**Consultation Response from KC,  
Lead Local Flood Authority****2024/92081 land adj, 36, Oxford Road, Dewsbury, WF13 4LL****Discharge of details reserved by conditions 3 (Remediation Strategy), 5 (CEMP:Biodiversity), 6 (CEMP), 7 (Arboricultural Method Statement), 8 (highway condition survey), 9 (Drainage strategy), 10 (Temporary drainage), 11 (BEMP) and 15 (oil / petrol inteceptor) of previous permission 2023/92712 for erection of 40 bed care home and 12 independent supported living units (use class C2) with associated works including the formation of car park and service access****Date Responded: 13/08/2024.****Responding Officer: Martin Stephenson****Responding Ref: 1****Previous response by the LLFA**

**Discharge of Drainage Conditions**

- LE-161 - SW Management Report, Rev B dated October 2023.
- LE-161-CCS-01-00-DR-S-0200, Proposed Drainage Layout, Rev P03 dated 12/01/2024.

Title:
PROPOSED BELOW GROUND
DRAINAGE LAYOUT

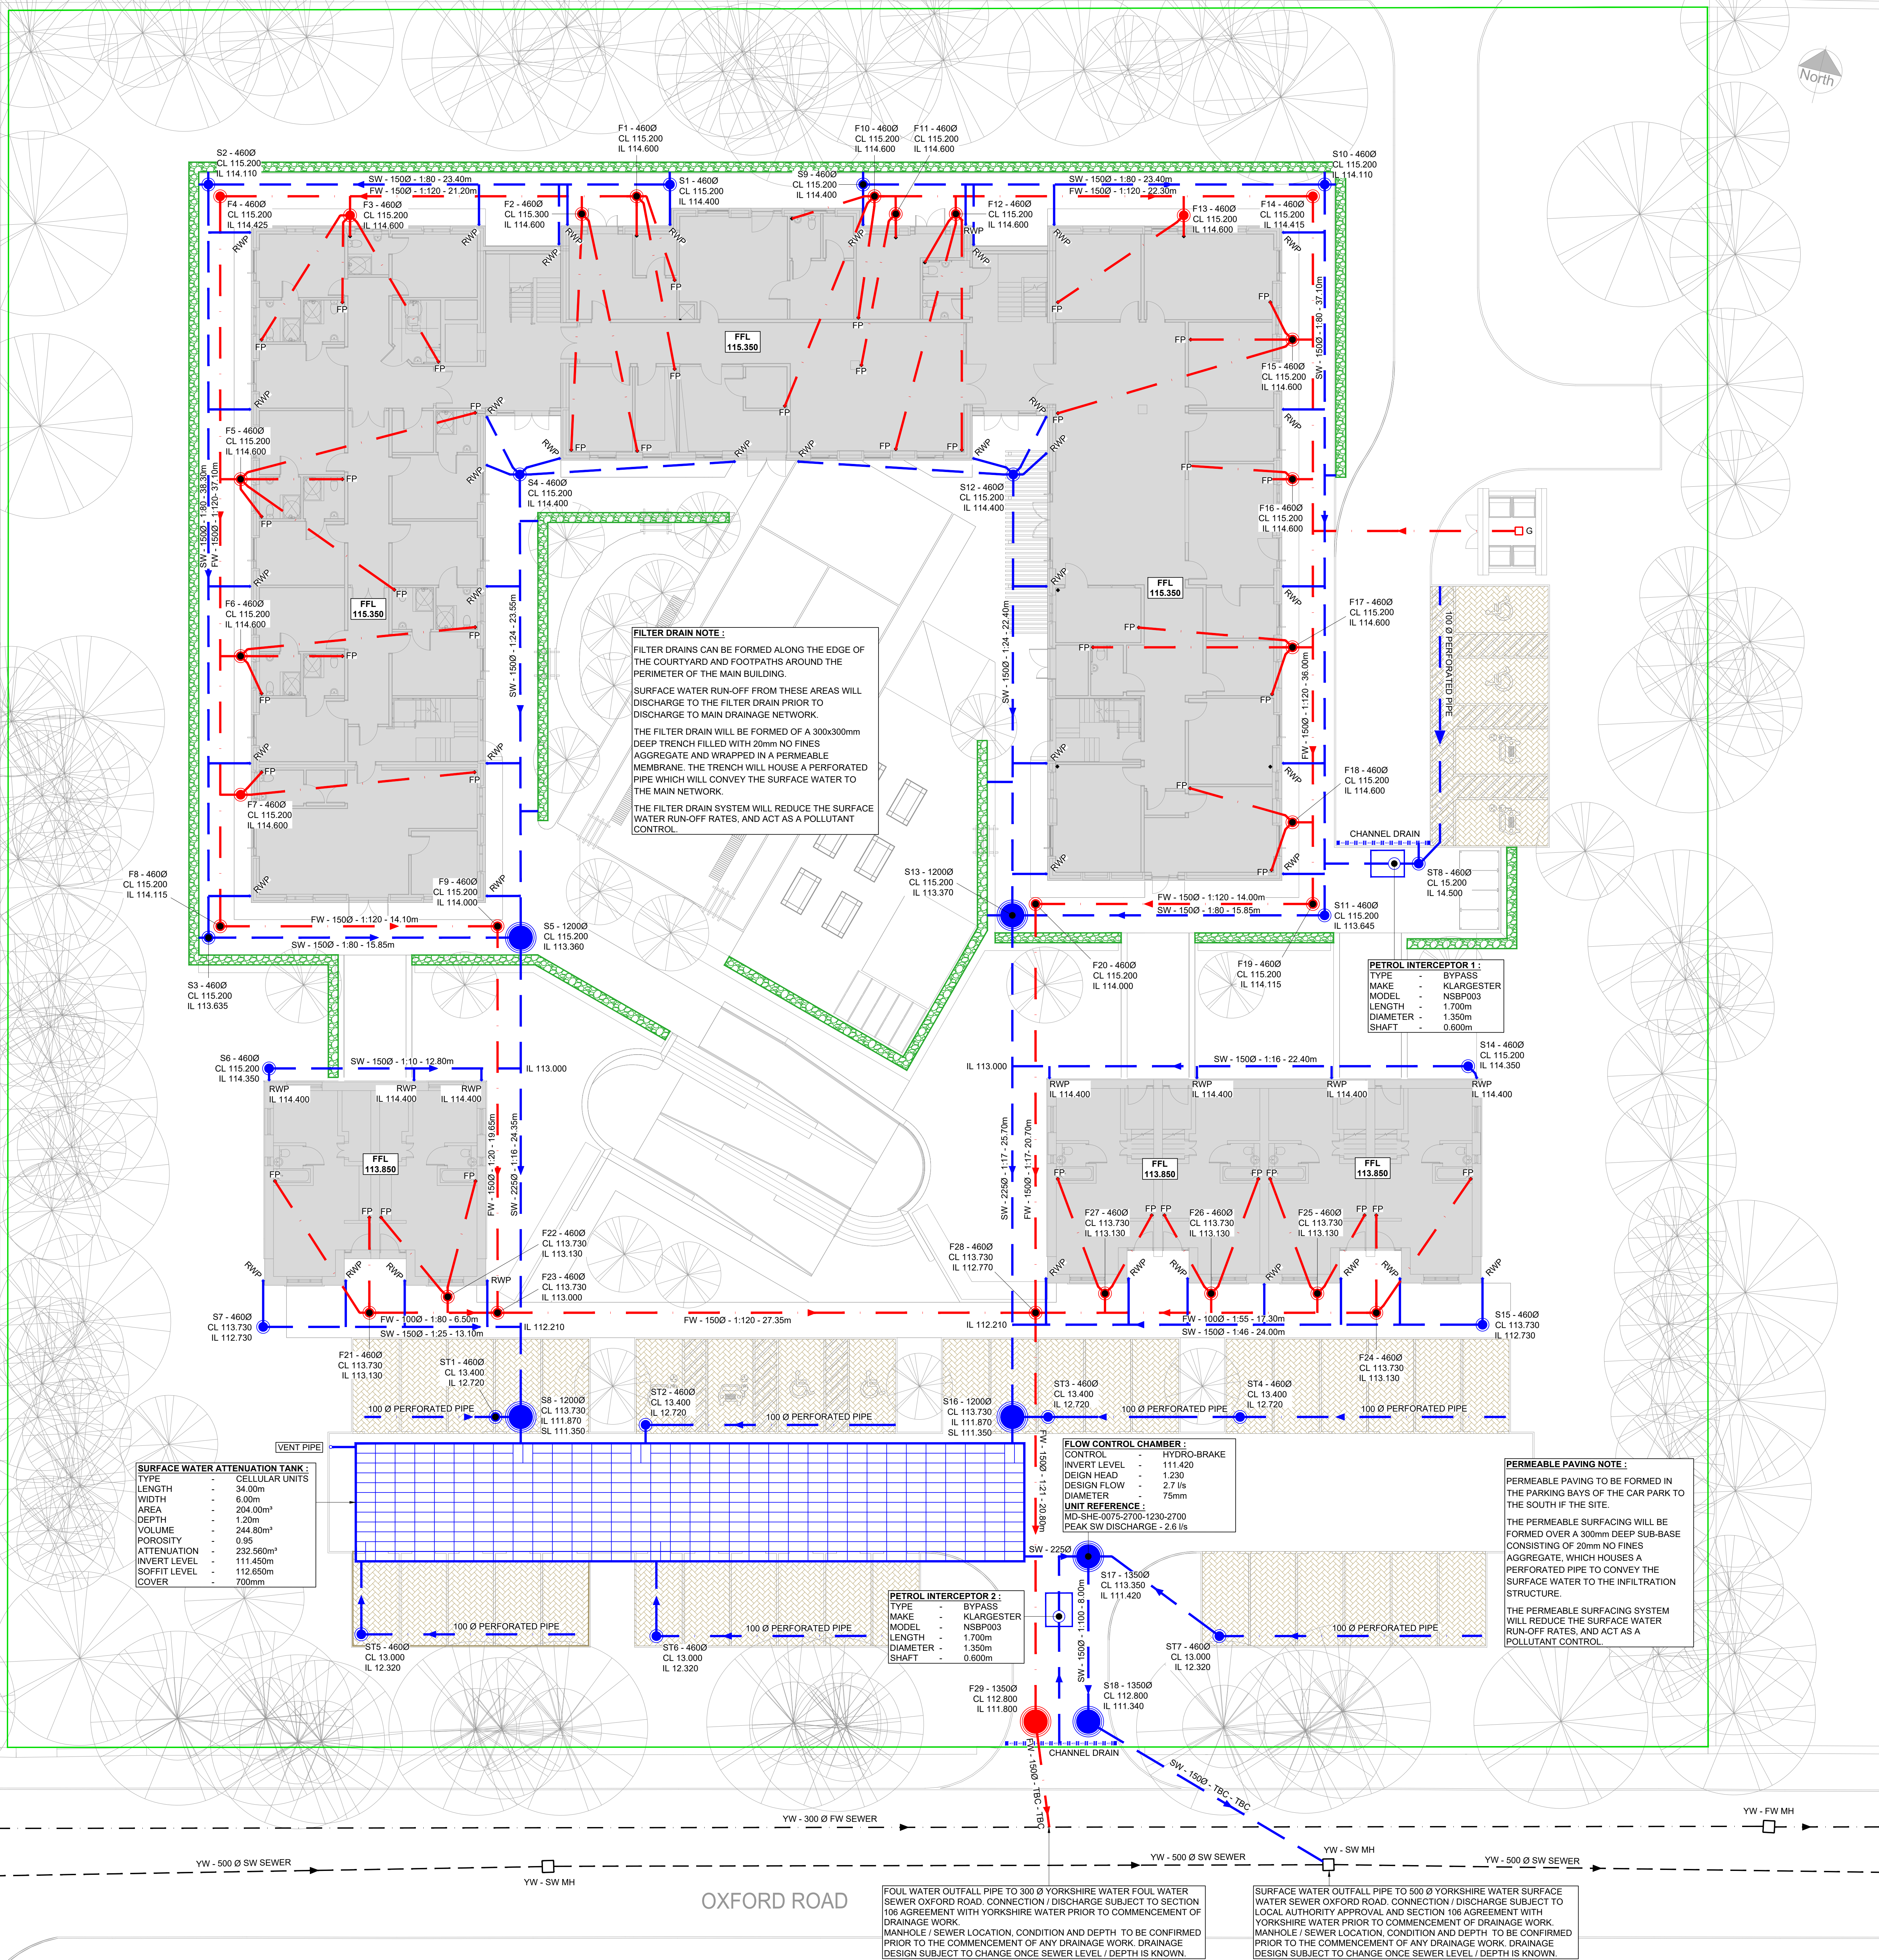
No access into the attenuation tank is shown to allow for the safe inspection and maintenance of the tank. This will be required to remove any accumulated silts within the tank.

Manholes at the inlets into the tank (i.e. ST2, 5, 6 &amp; 7) should be of the catchpit type and be a minimum 900mm diameter to reduce the risk of sediments entering the tank

The SW Management Report (Rev B) has not been revised to take into account the LLFA's previous consultation comments dated 03/11/2023. Please revise the report accordingly including the removal of the complex flow control and replacement with a single 75mm diameter hydrobrake rated at 2.7 l/s (as shown on the Proposed Drainage Layout), the revised volume of the attenuation tank.

It is noted that parking areas are surfaces with permeable paving and, as such, there is no longer any requirement for oil/petrol interceptors as the sub-base under the paving will provide treatment of any pollutants from vehicles. The interceptor connected to the channel drain at the entrance to the site is

also not required as the area of road draining through it is less than the required 800m<sup>2</sup>.
